DRB Application No.: 10DRB-70197

Project Name: *North Albuquerque Acres*

TO: Jack Cloud, DRB Chair
FROM: Suzanne Busch, Principal Engineer
SUBJECT: Project # 1008401 Major Site Development Plan for Building Permit
Dr. Bill Hawk, North Albuquerque Acres

DRB Comments

① Area Site Plan
 Scale: 1" = 40'

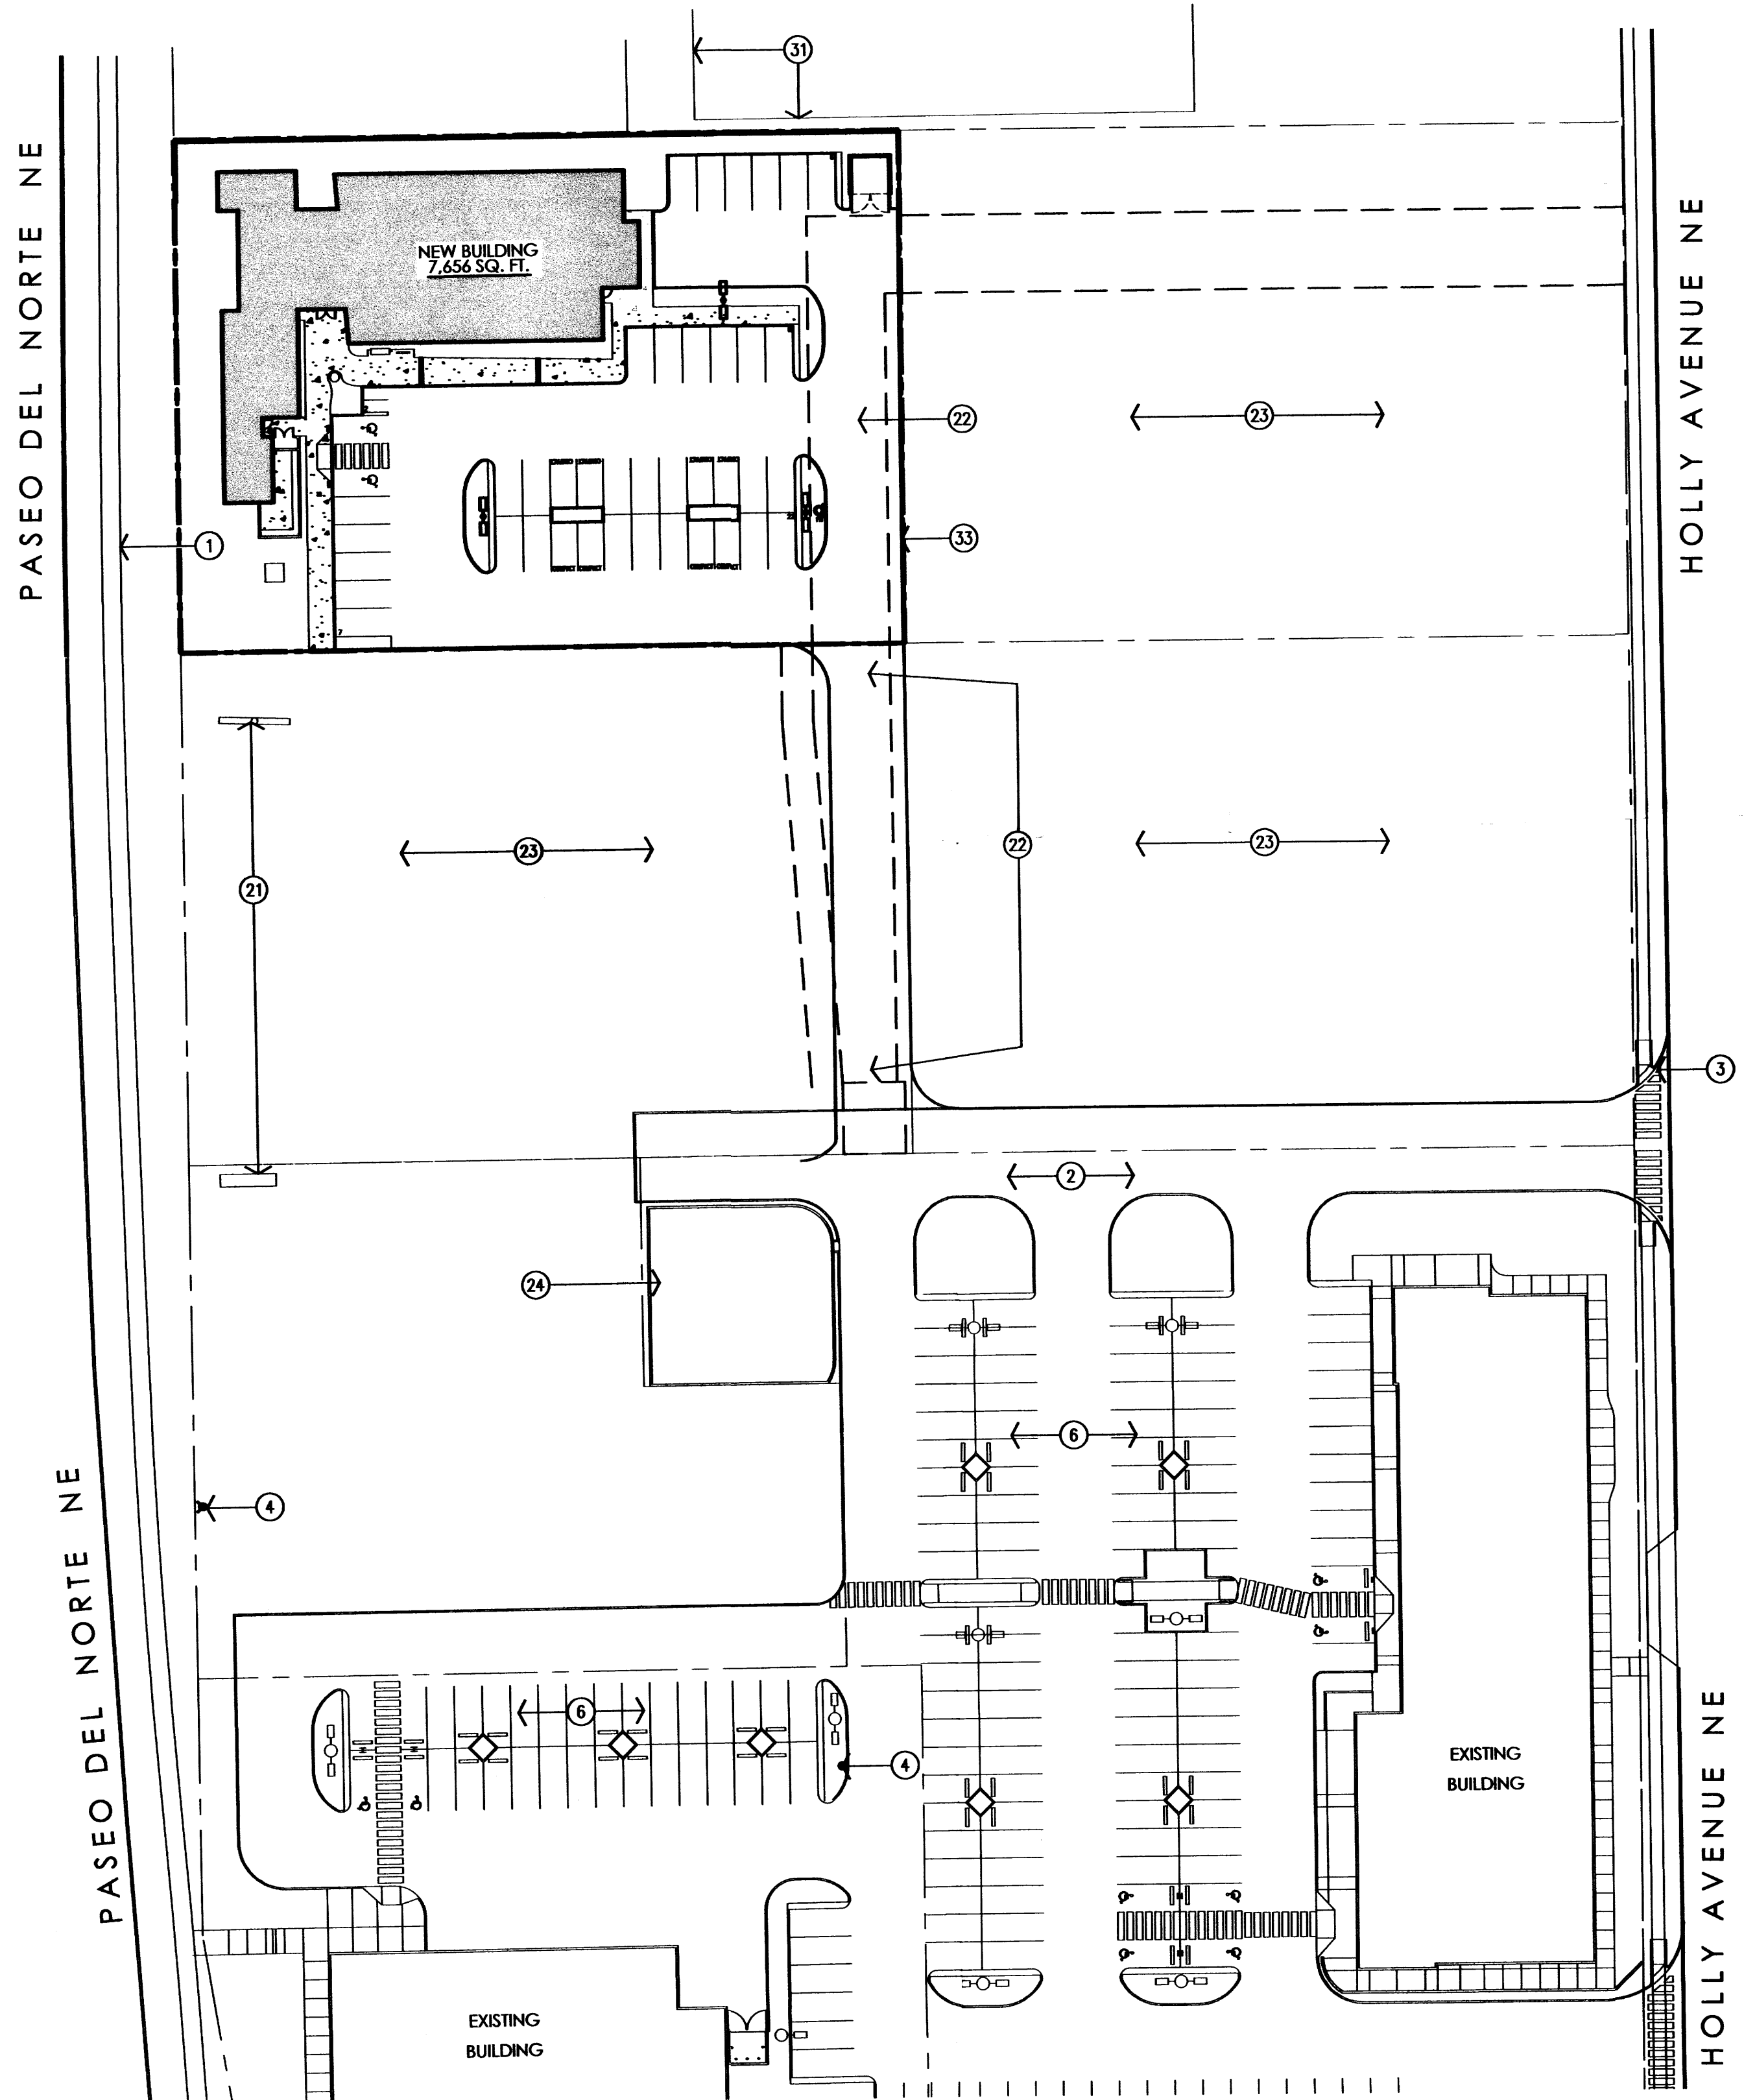
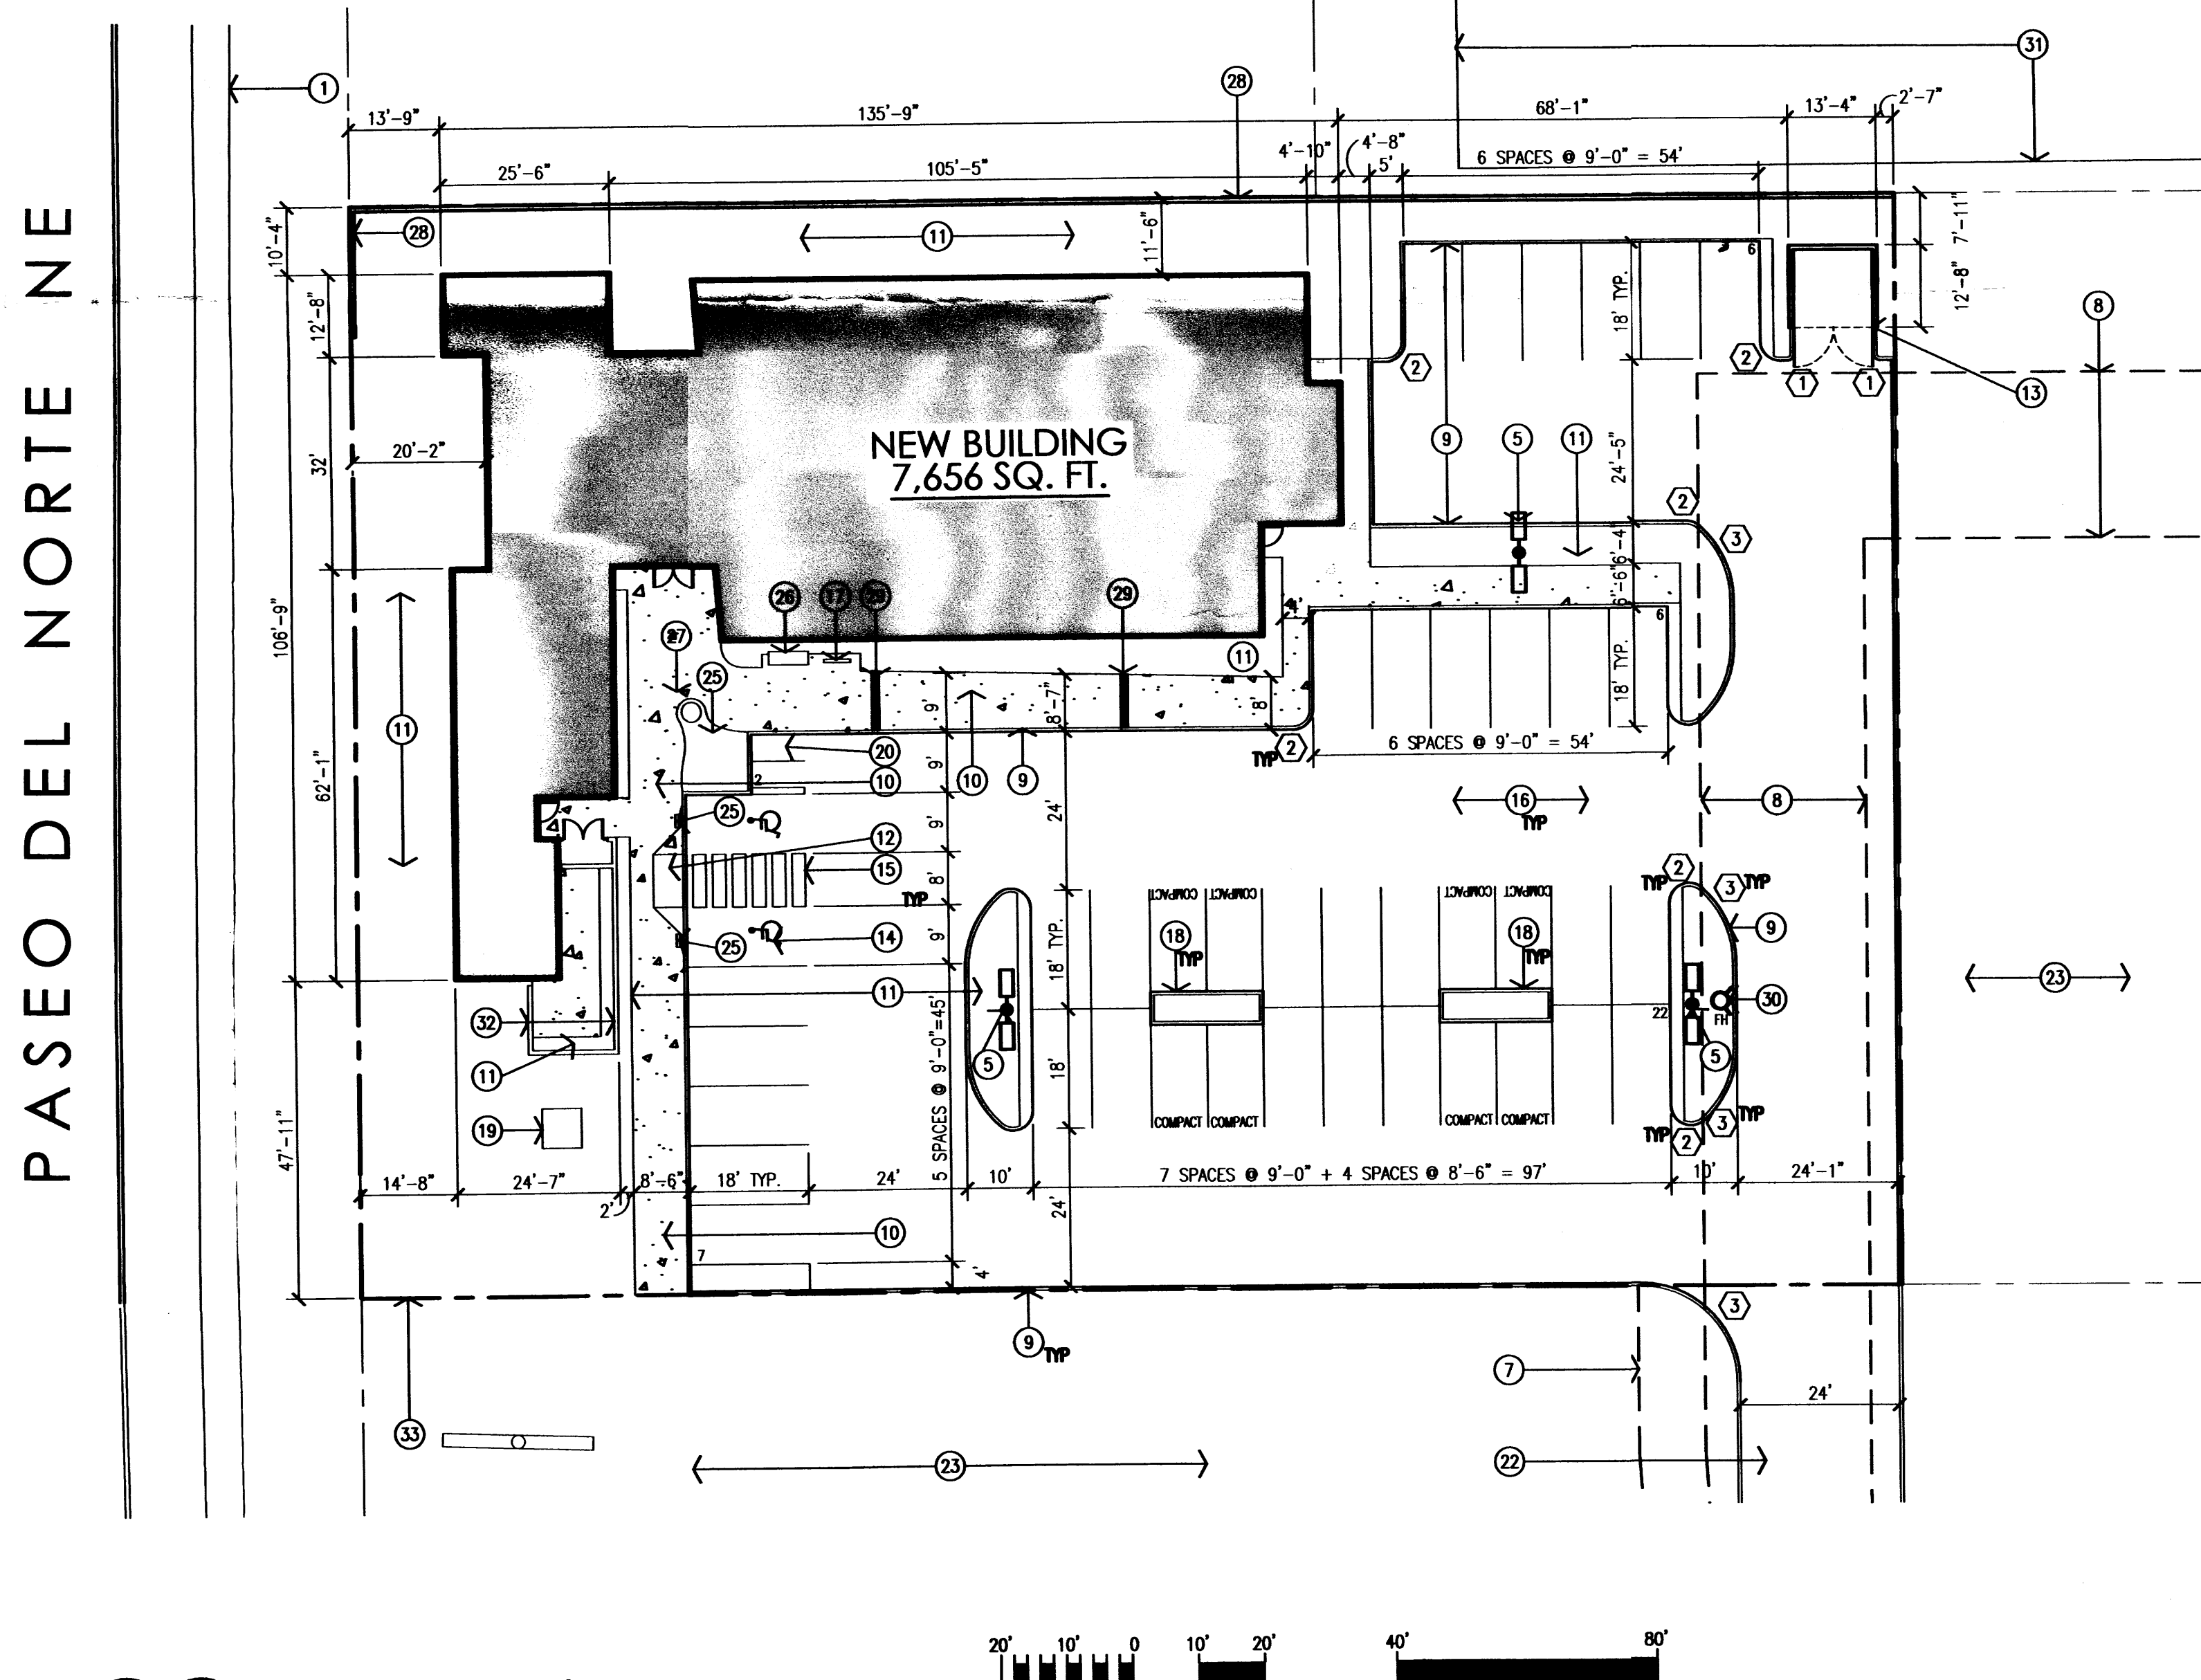
2. The following disclosure statement should appear on the cover sheet of the site development plan:

The subject property is located near a former landfill. Due to the subject property being near a former landfill, certain precautionary measures may need to be taken to ensure health and safety of the public. Recommendation made by a professional engineer with expertise in landfills and landfill gas issues (as required by the most current version of the *Interim Guidelines for Development within City Designated Landfill Buffer Zones*) shall be consulted prior to development of the site.

- 1) per the sector plan, landscape buffer is not required if the lot line is within a common access easement (however, a 6 foot buffer would be required on side yards – not 4'7")
- 2)) and 5) refer to comments from ABCWUA, and contact the franchised utilities regarding their easement needs
- 3) it appears an infrastructure list may be required for water and sewer – refer to comments from ABCWUA, and from Transportation Development regarding the access drive (this can sometimes be part of the building permit, and might not need to be on the list as 'off-site')
- 4) the cross easements appear adequate, but will be fully reviewed with the application for site plan approval – refer to comments from Hydrology, but typically drainage will need to conform to a master drainage plan
